**From:** [Sandra Layton](#)  
**To:** [Chace Pedersen](#)  
**Cc:** [lukupugs@fairpoint.net](mailto:lukupugs@fairpoint.net); [Jamey Ayling](#); [Zach Torrance-Smith](#); [Carri Wullner](#)  
**Subject:** Re: ACU-23-00003 Atlas - Transmittal of Comments  
**Date:** Tuesday, September 19, 2023 9:15:54 AM  
**Attachments:** [Responses to Health Concerns of Towers.pdf](#)  
[Housing impacts and health info.pdf](#)  
[Response to comments.pdf](#)  
[Screen Shot 2022-10-03 at 3.46.24 PM.png](#)

Please see the attached correspondence regarding your Administrative Conditional Use application (ACU-23-00003 Atlas). A physical copy of the correspondence will be placed in the mail. Please let me know if you have any questions or concerns.

Response to Public (Neighborhood) Comments

#### Responses to Agencies:

TOWER ELEVATION

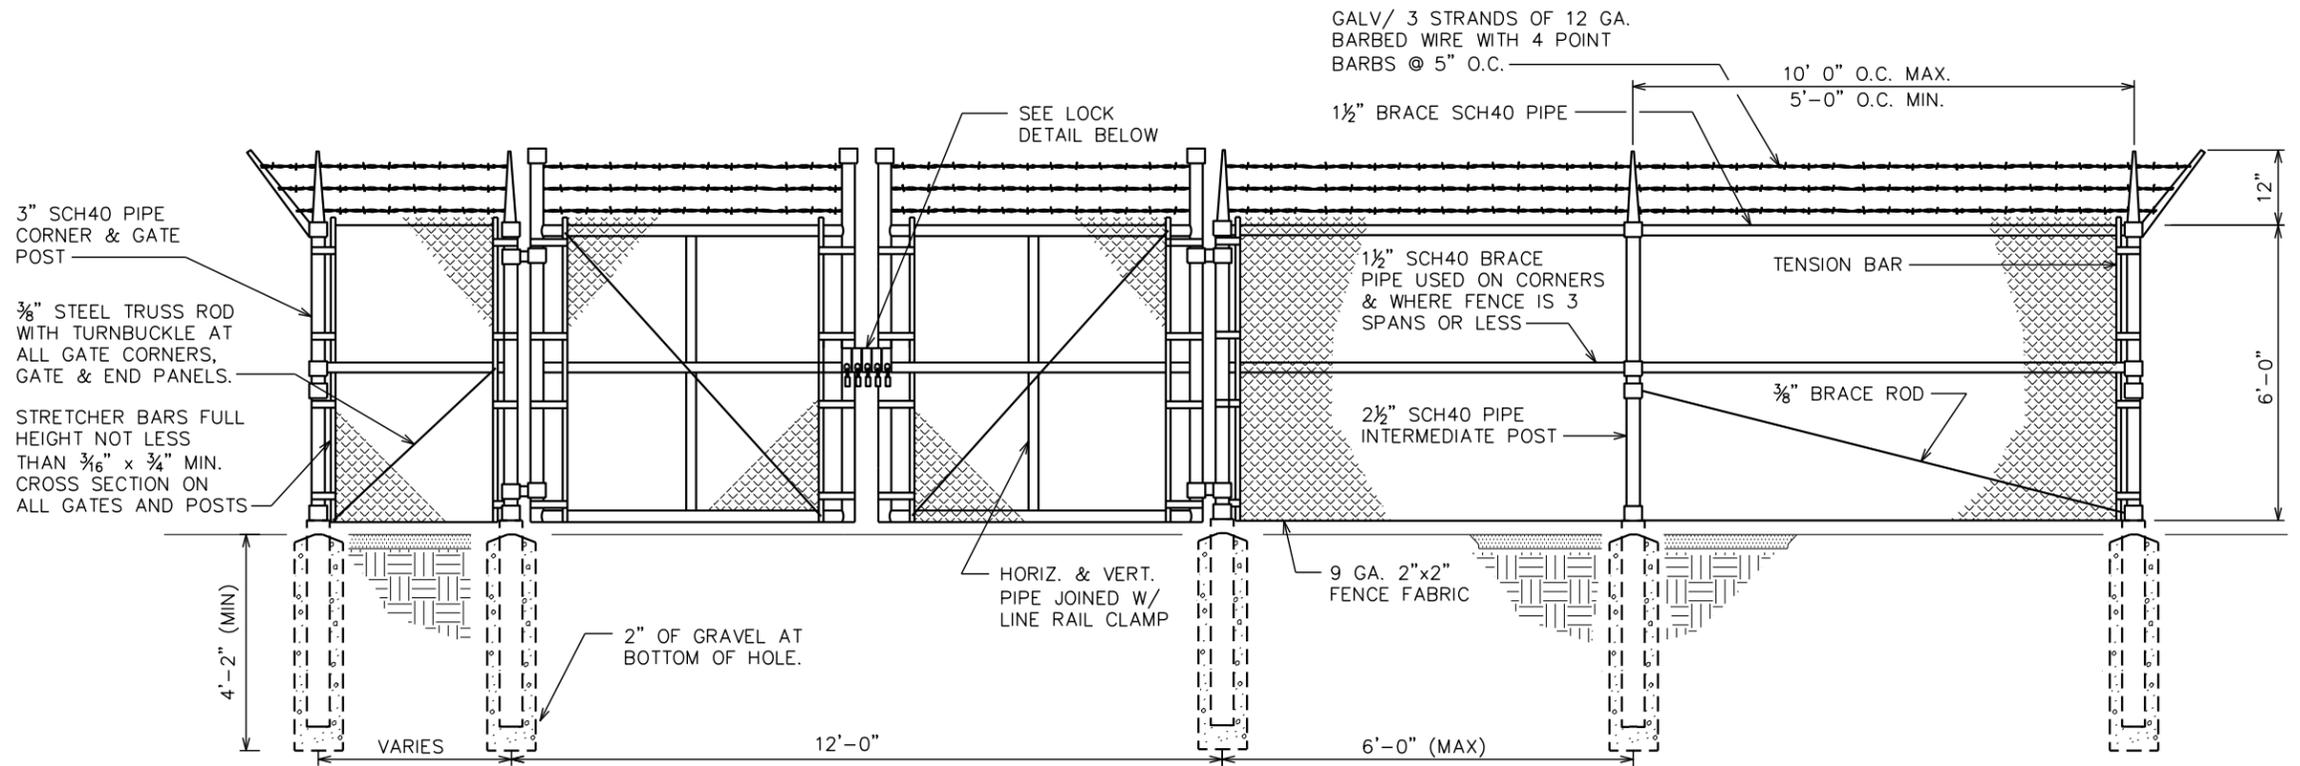
1. Health Concerns:
  - a. Please find the attached document with additional information regarding health concerns.
2. Concerns with the visual aesthetics:
  - a. We will have our design updated to reflect the use of a compatible color to camouflage the tower. I have attached color swatches for you to review and choose which color is preferred.

4. Concern of the tower having a flashing light and shining in windows
  - a. We have already received approval from the FAA and confirmed that no light will be required for this tower.
